Project ref: M25 junction 10/A3 Wisley
interchange improvement –
TR010030

Application by Highways England for an Order Granting Development Consent for the M25 Junction 10/A3 Wisley interchange improvement project

Please find enclosed our comments for 'deadline 1' submissions for the M25 Junction 10/A3 Wisley interchange improvement project Development Consent Order application.

Summary table of EA comments, queries & issues (Relevant Reqs stage – Sep 2019)

Figure 2.2: Stratford Brook with modelled 1 in 100 +35% flood extent

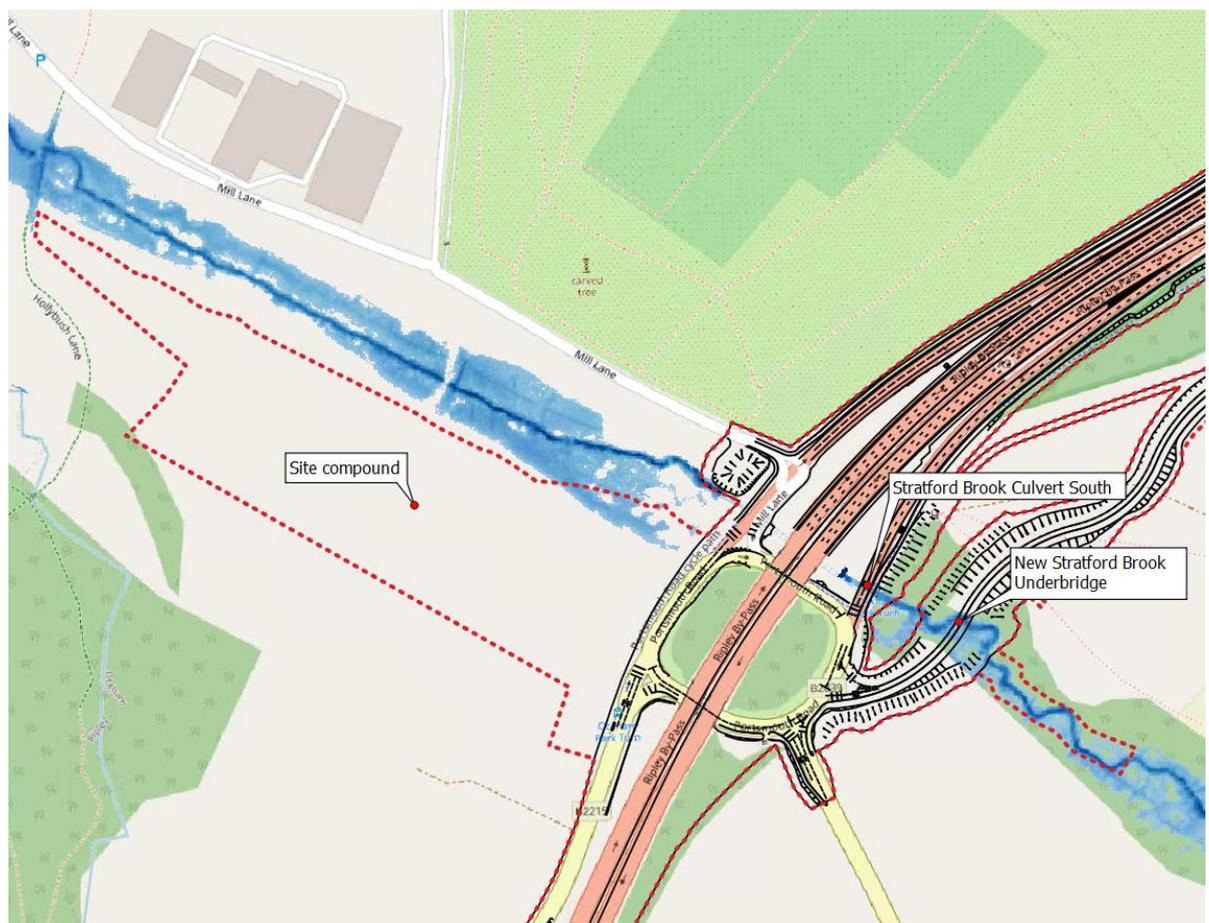
034 (JM)	Issue	Flood risk	FRA	It's extremely frustrating that more drawings have not been included as appendices to this FRA to explain the works in this area in more detail. We would of at the very least expected a layout drawing	Update FRA accordingly.	If the opportunity arises during Examination for the FRA to be updated, additional drawings can be added. It is understood that this is a recommendation	Agreed.

showing existing and post development situation, with flood extents overlain to show clearly that flood risk was not being increased. This would have been extremely useful for the reader.		from the EA to improve the readability of the FRA, but not an issue that precludes the EA from agreeing with the FRA conclusions.	
035 (JM)	Issue	Flood risk	FRA	We therefore recommend that the FRA is updated to include more information clearly demonstrating the reader that flood risk is not increased in the Stratford Brook area.	Update FRA accordingly.	Given the notes in comment 032, it is understood that this is a recommendation from the EA to improve the readability of the FRA, but not an issue that precludes the EA from agreeing with the FRA conclusions.	Under discussion.
036 (LC)	Comment	Flood risk	FRA	I do take issue with the flood risk assessment (FRA) that has been undertaken which I believe is limited in detail.	None.	Noted.
